RE: Aspect Industrial Estate Modification 2 – SSD 10448 Proposed Mod 2 – Response to Submissions

TABLE 1: RESPONSE TO COUNCIL COMMENTS

DESIGNED RebeccaBMadden	PAPER SIZE A3	CLIENT Mirvac	DOCUMENT INFORMATION	
APPROVED BY X.XXXX	DATE 03.03.2022	PROJECT 1897	DESIGN ASSESSMENT	
SCALE 1:3000	NTS	Lots 54-58 Mamre Road, Kemps Creek	GENERAL NOTES	
			FILE NAME AG1897-01-v05.dwg	SHEET AG01

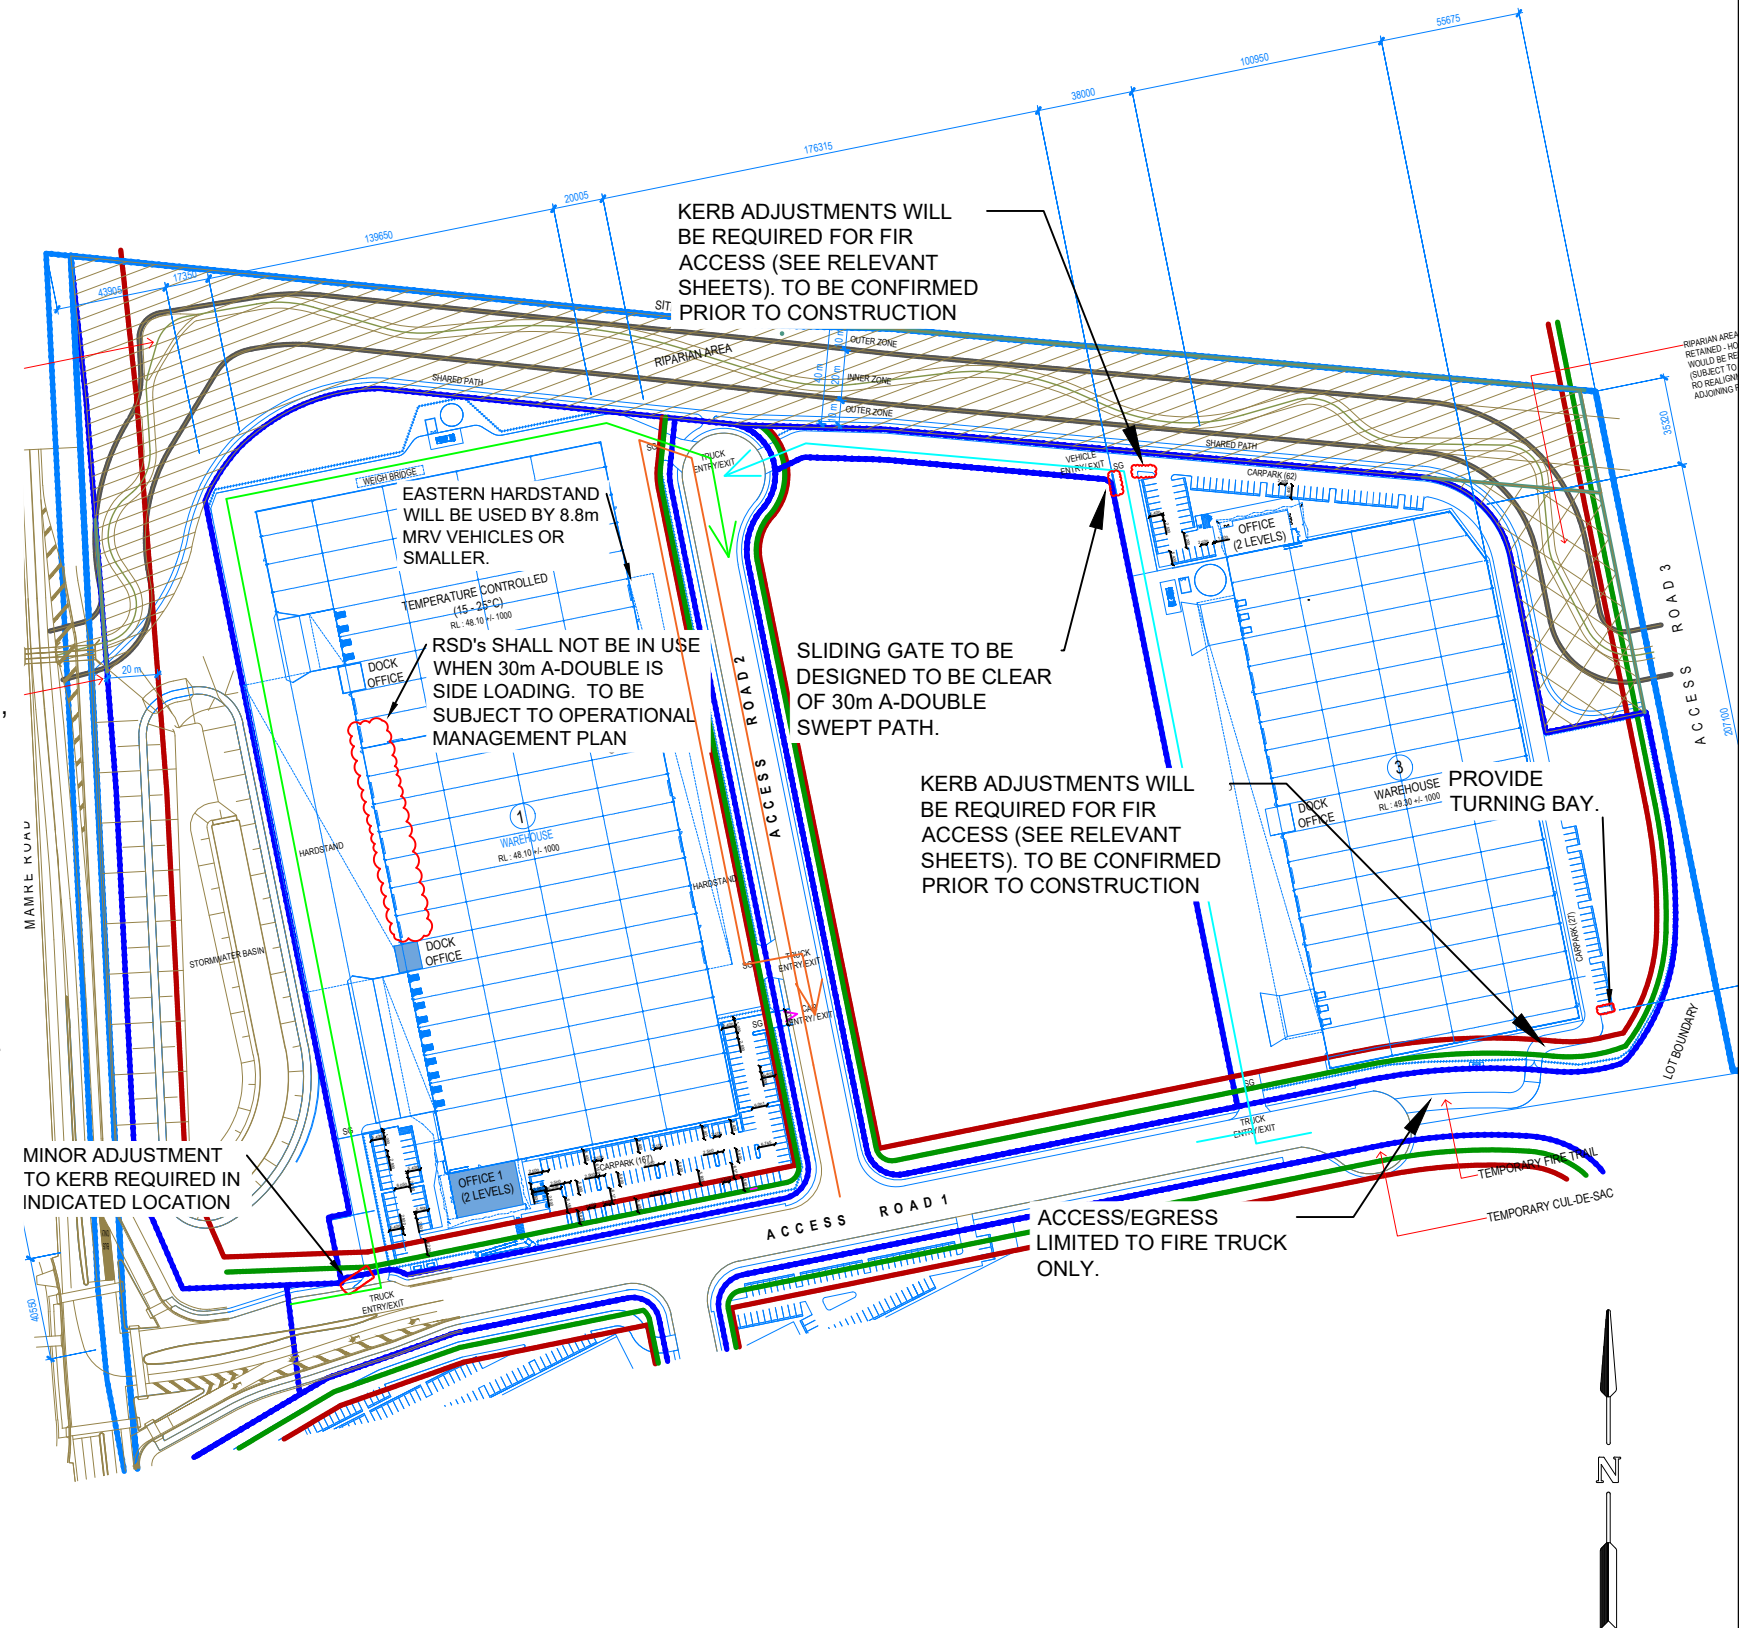
<p>The proposed internal circulation roadways for Warehouse 3 shared between passenger vehicles accessing the carpark and heavy vehicles accessing the hardstand this is not supported on safety grounds.</p> <p>Swept path assessments were not included in the Appendix of the updated traffic report and in this respect DPE should request and review.</p>	<p>As above, see response to Item 2 (b).</p>

<p>to be provided to ensure that light vehicles exiting the car park have priority.</p> <p>This will form part of the signage design requirements, which is detailed prior to the occupation. It is anticipated that this could be ensured via a suitable Condition of Consent, to prepared by a suitably qualified consultant during detailed Construction Certificate design coordination.</p> <p>Further to the above, a minor change has been made to layout, to ensure that the exiting heavy vehicle would not cross over the centre of the driveway. Thus, therefore would be no conflicts between light and heavy vehicles.</p> <p>Swept path analysis for Warehouse 3 on the updated masterplan is annexed in Appendix A.</p>
